# RFS

Your reference: SSD-70748466  
Our reference: DA20250726002963-Response to Submissions-1

**State Significant Development – Response to Submissions – Residential Subdivision/Masterplan  
Response to Submissions - Huntlee New Town - Stage 2 (SSD-70748466), (none)**

- BAL-12.5
- BAL-19
- BAL-29
- BAL-40
- BAL-FZ

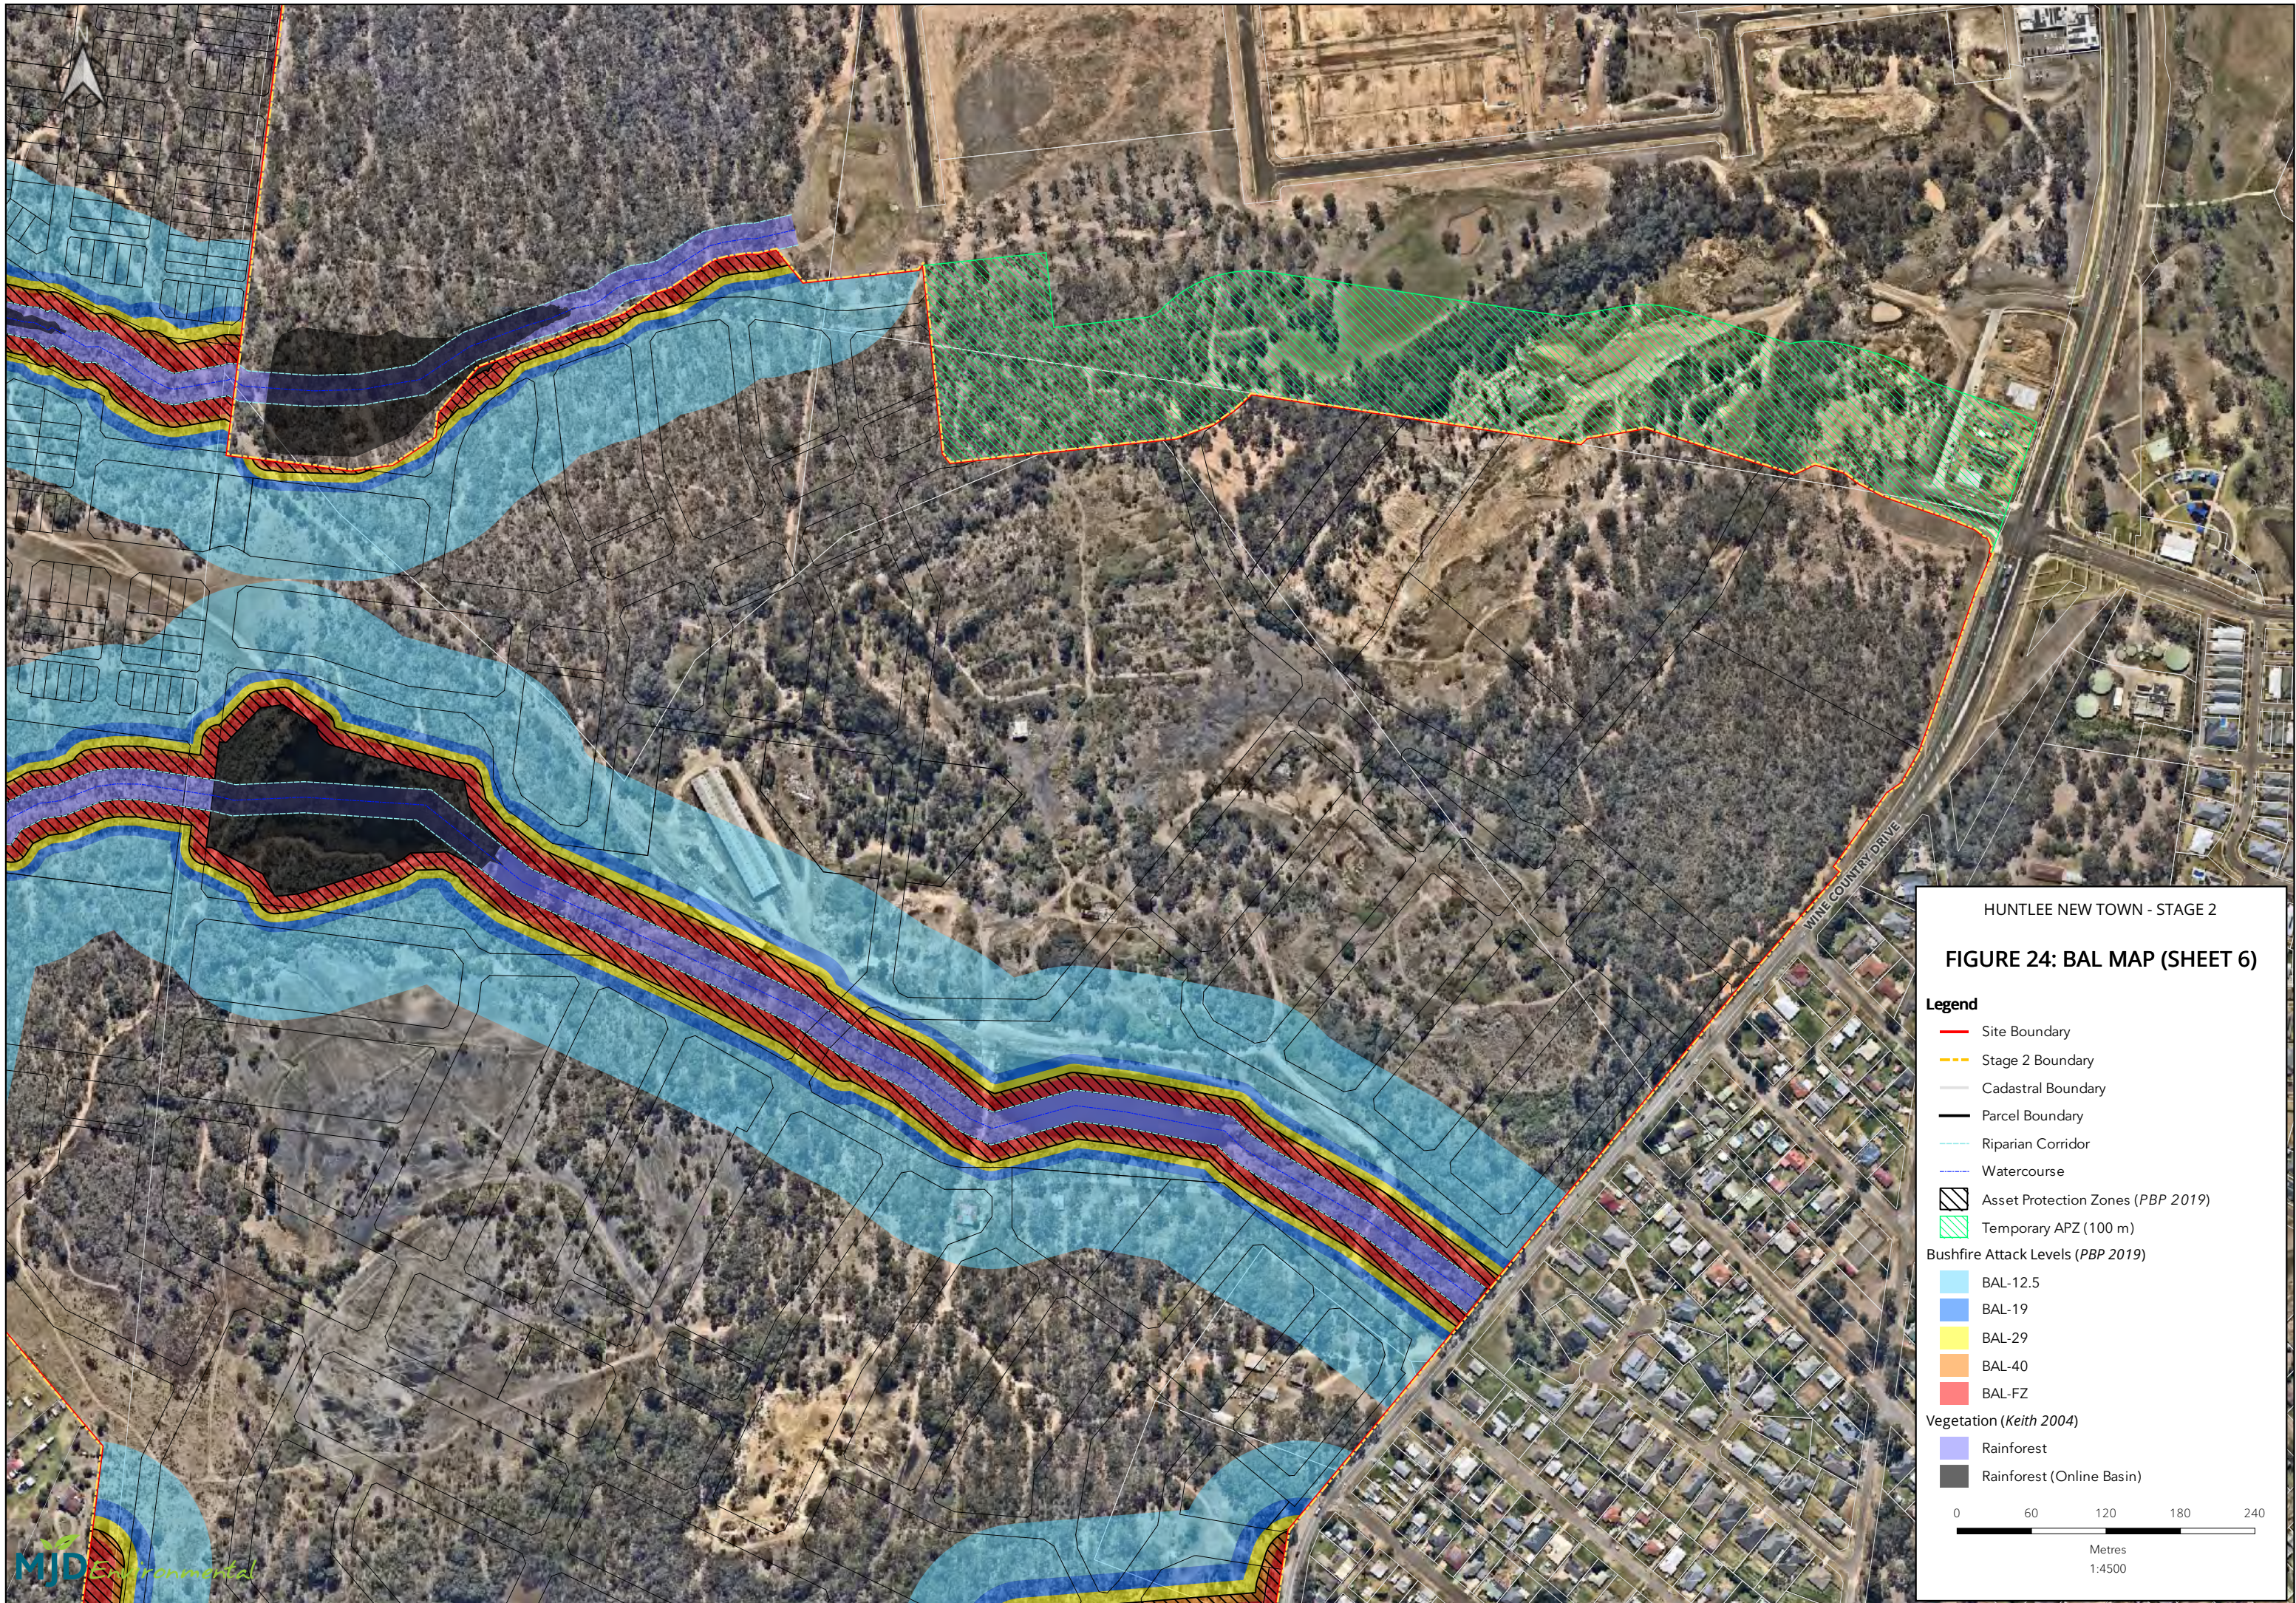
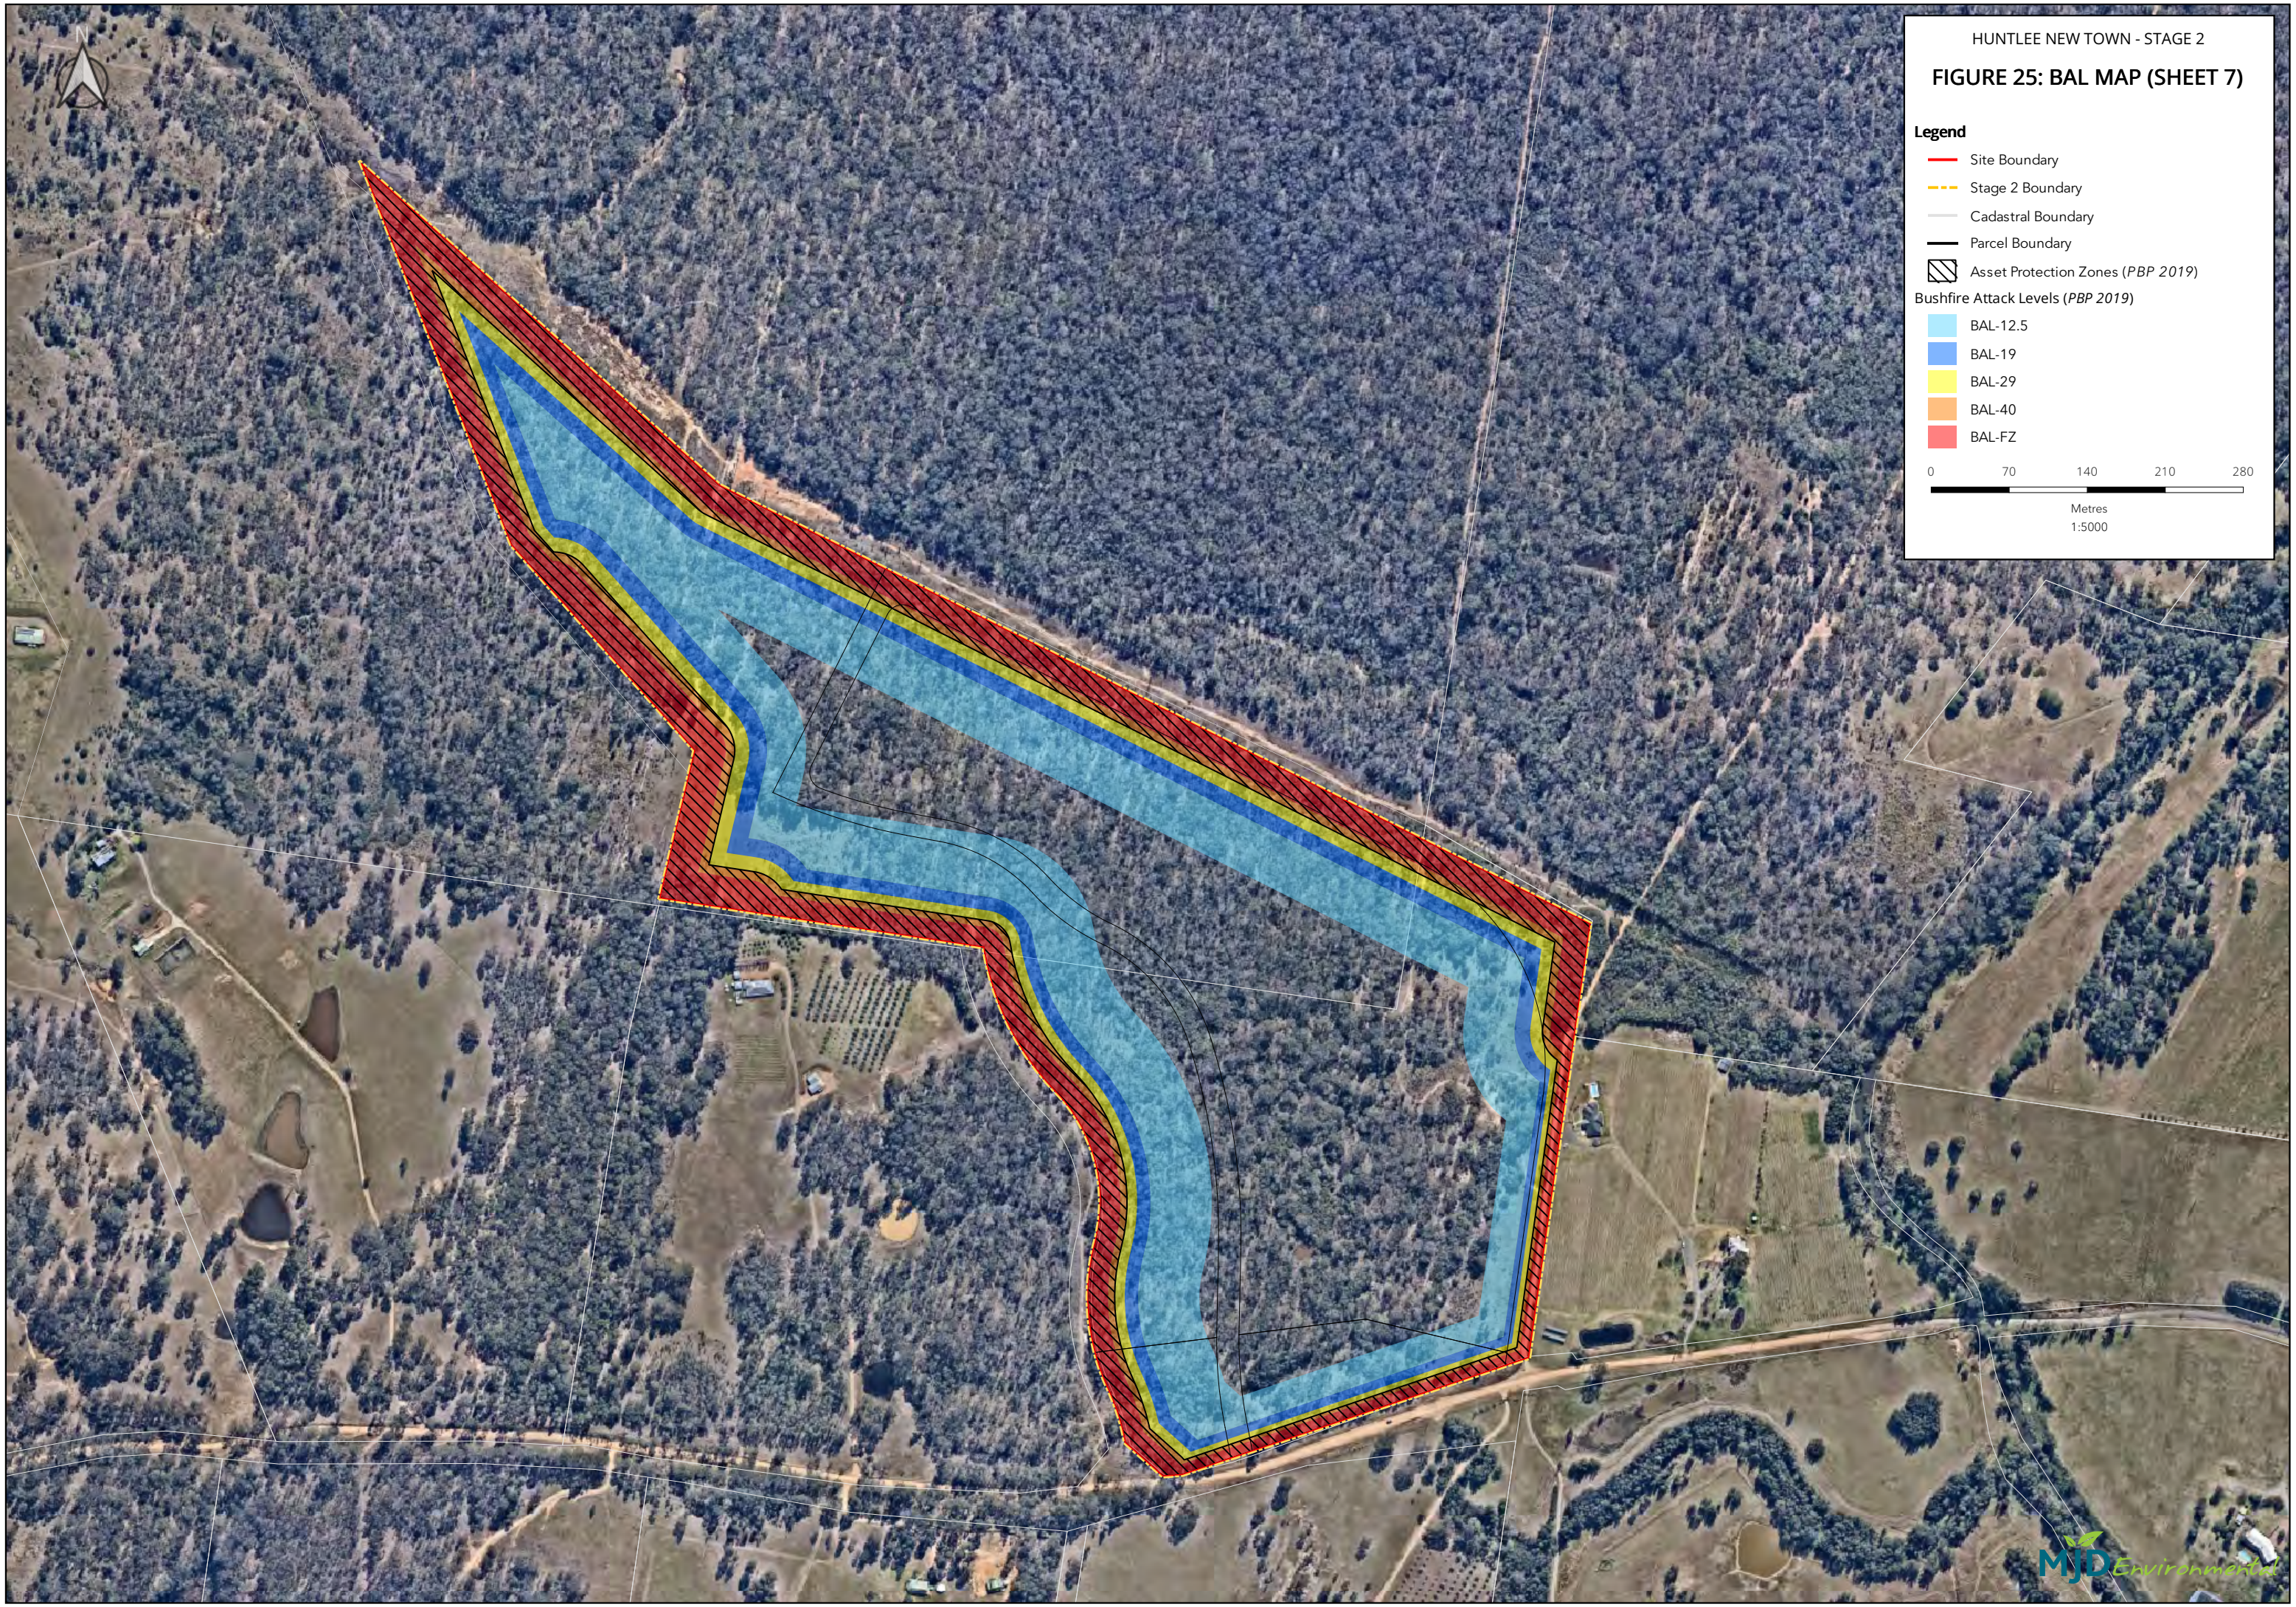
3. A bush fire attack level (BAL) Table must be prepared with regard to the comments above, with a BAL Plan identifying the lot numbers and BAL ratings applicable to future dwellings on lots within the subdivision of Village 2. The BAL Plan provided in Figures 20 to 25 in the bush fire report prepared by MJD Environmental (dated 11/06/2025, V.4, referenced Z:\16015 - Huntlee, Branxton) cannot be relied upon for future development as there is insufficient information provided in relation to establishment of APZs offsite and vegetation management of drainage basins.
